13th May 2021

Application No: Y/41/21/HH
Site Address: Ferndale House Burndell Road Yapton BN18 0HT
Description of works: Demolition of single storey side extension and two storey rear extension. Erection of new two storey side / rear extension. Insertion of projecting rear dormer window and rooflights to front and rear. Erection of front boundary low wall and gates.

Ferndale House Y/41/21/HH

1308/ PL-06

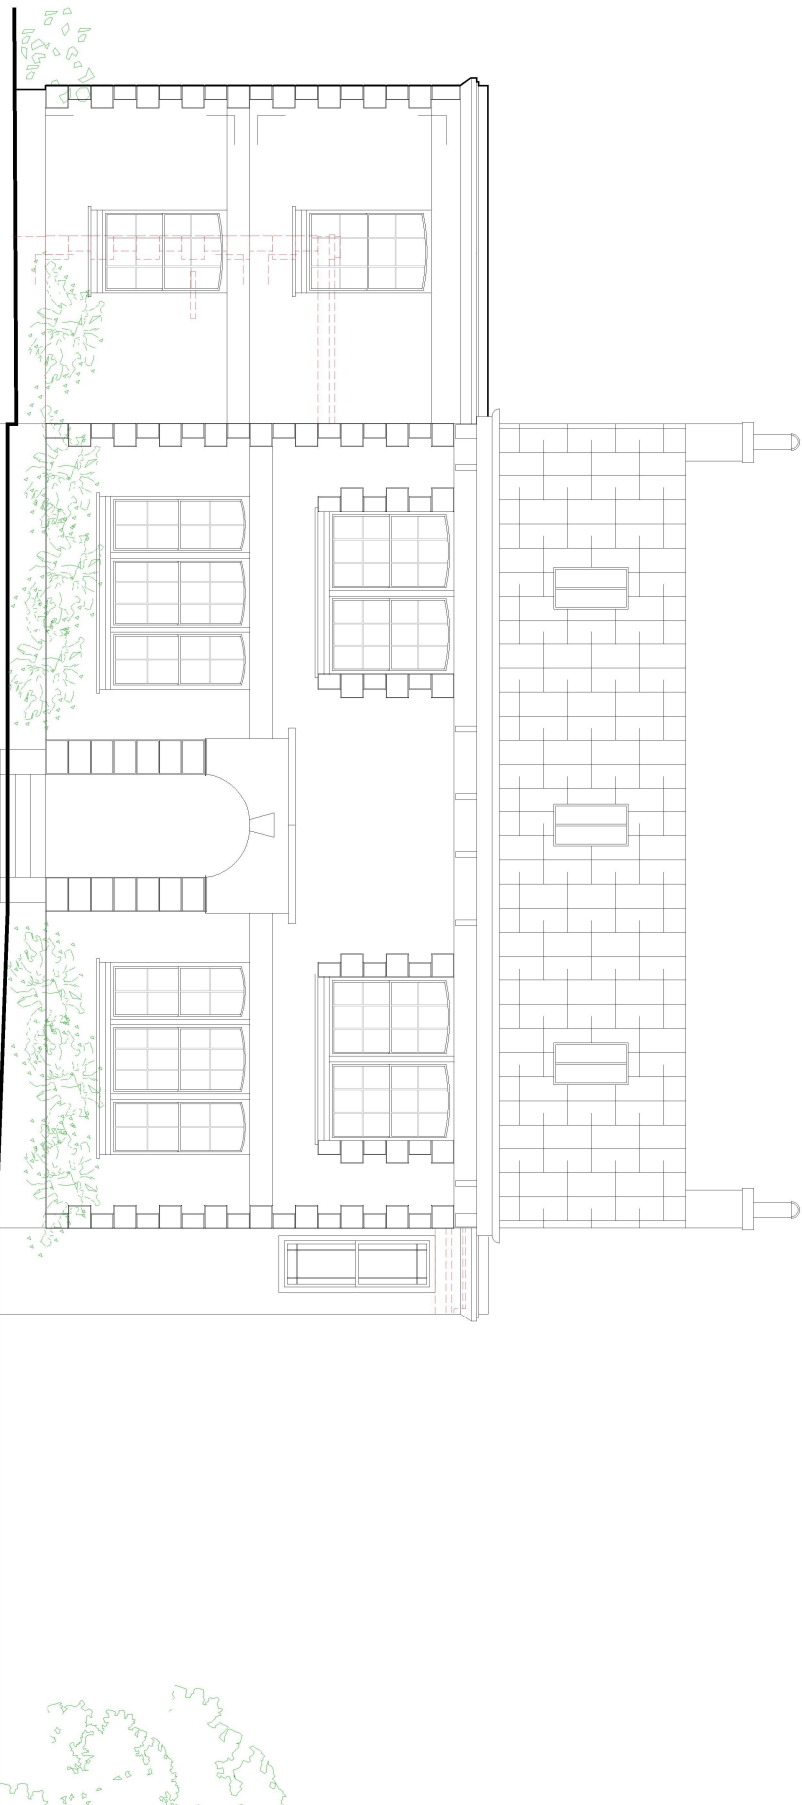
YPC has fully considered this application and would insist that the front elevation is treated with the utmost sensitivity in terms of materials to ensure that the historic integrity of the building is not diluted or eroded.

YPC would seek conditions to ensure appropriate materials are used throughout and that the proposed extension remains appropriate to the plot size.
